5. The Geotechnical Report Note on the Grading Plans (CORE, December 2021) should be updated to include RMG's most recent revision (July 2, 2021).

FINAL SITE GRADING CONSTRUCTION PLANS
FOR
THE RIDGE AT LORSON RANCH FILING NO. 1
FINAL GRADING / EROSION CONTROL PLANS

SHEET No.  
**FIG-2.1**

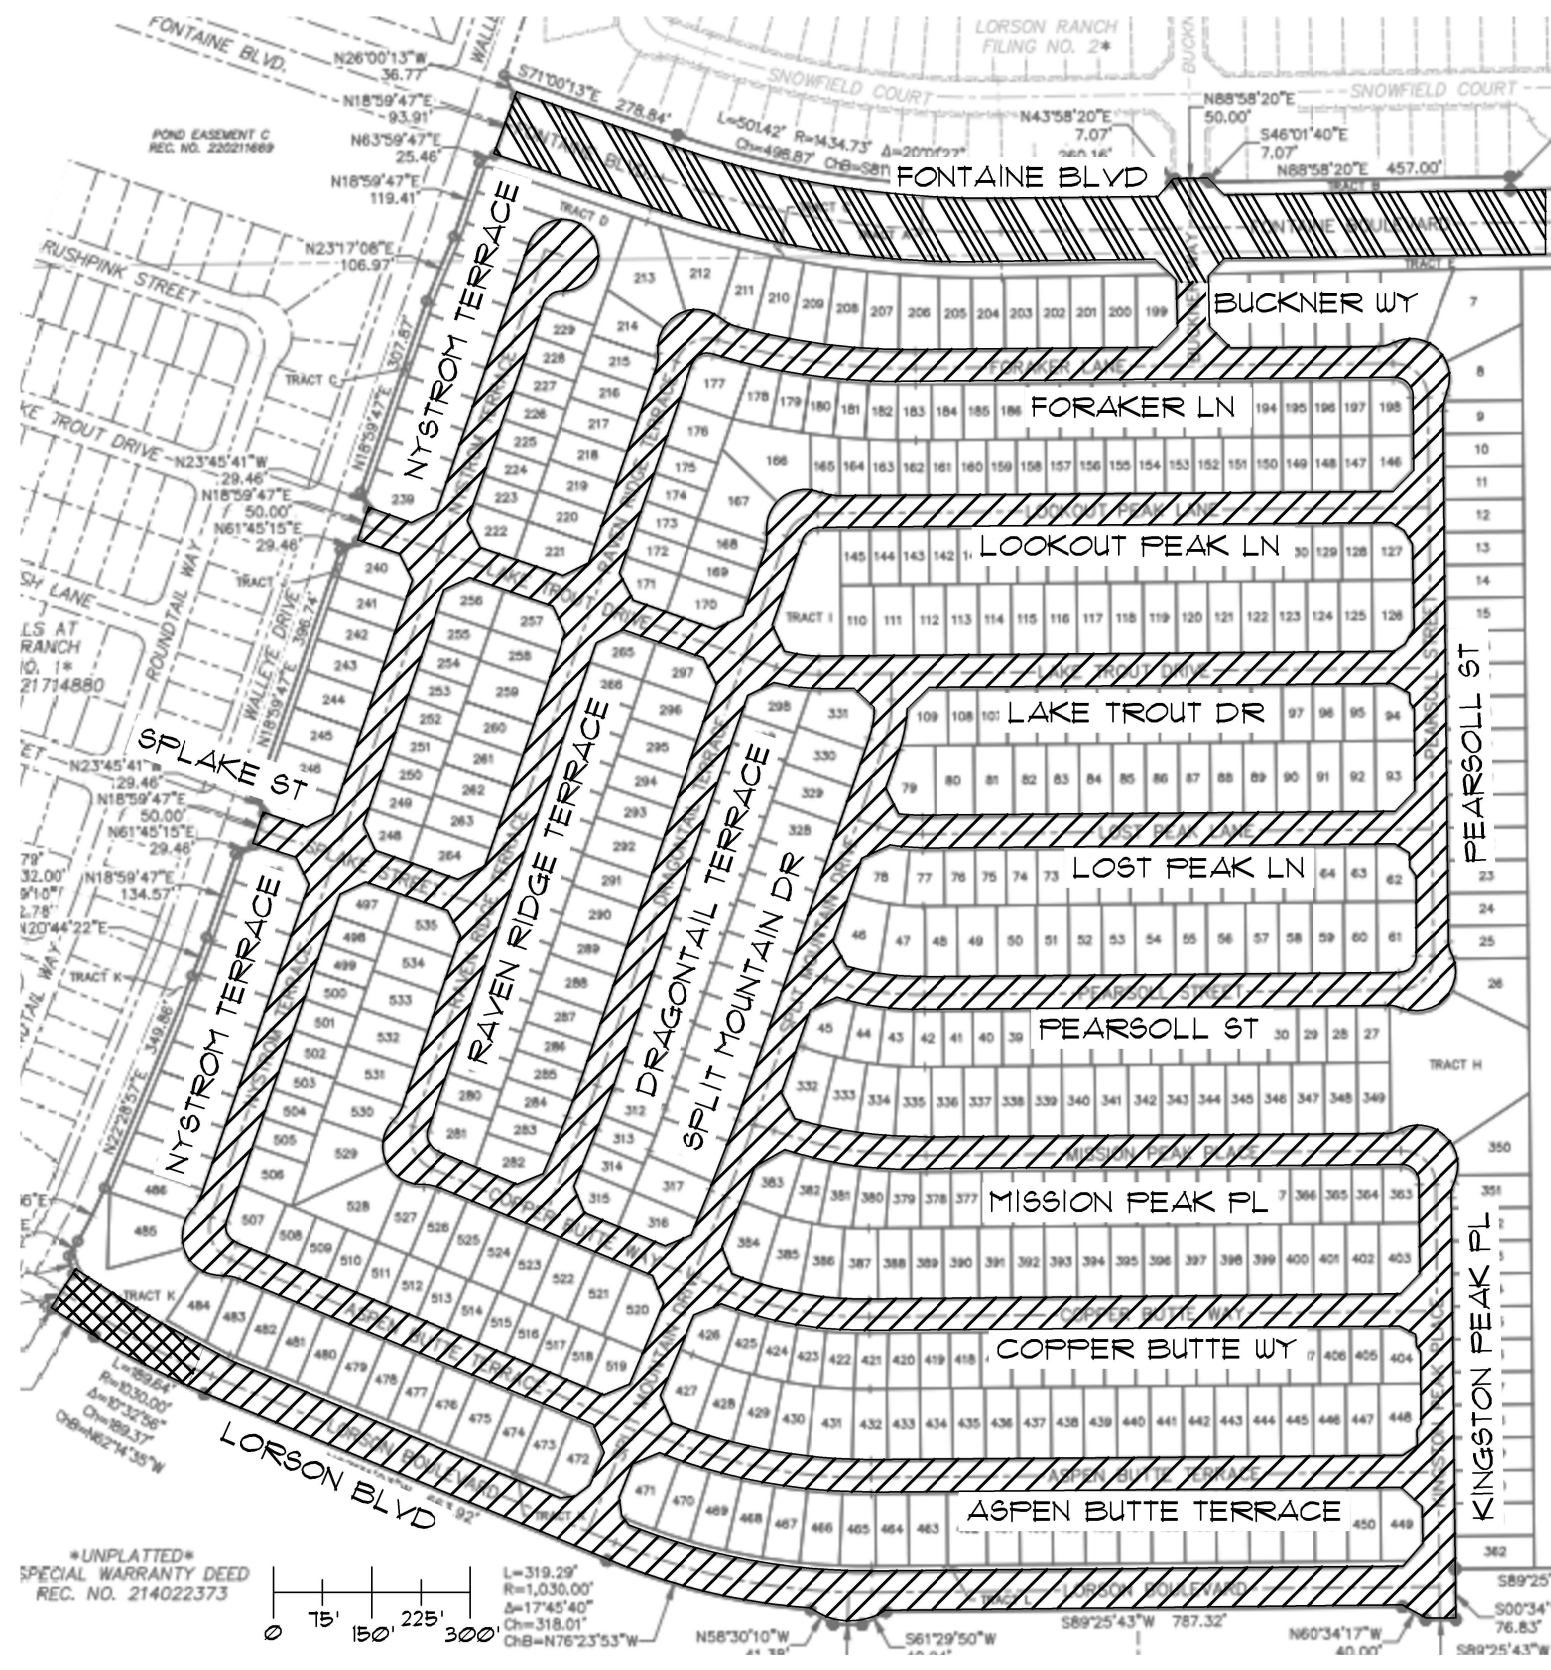
4. Some of the test borings in FIG-2 of RMG's report are not labeled or missing (i.e. D-52 to D-58, D-61 to D-65, D-67 to D-70).
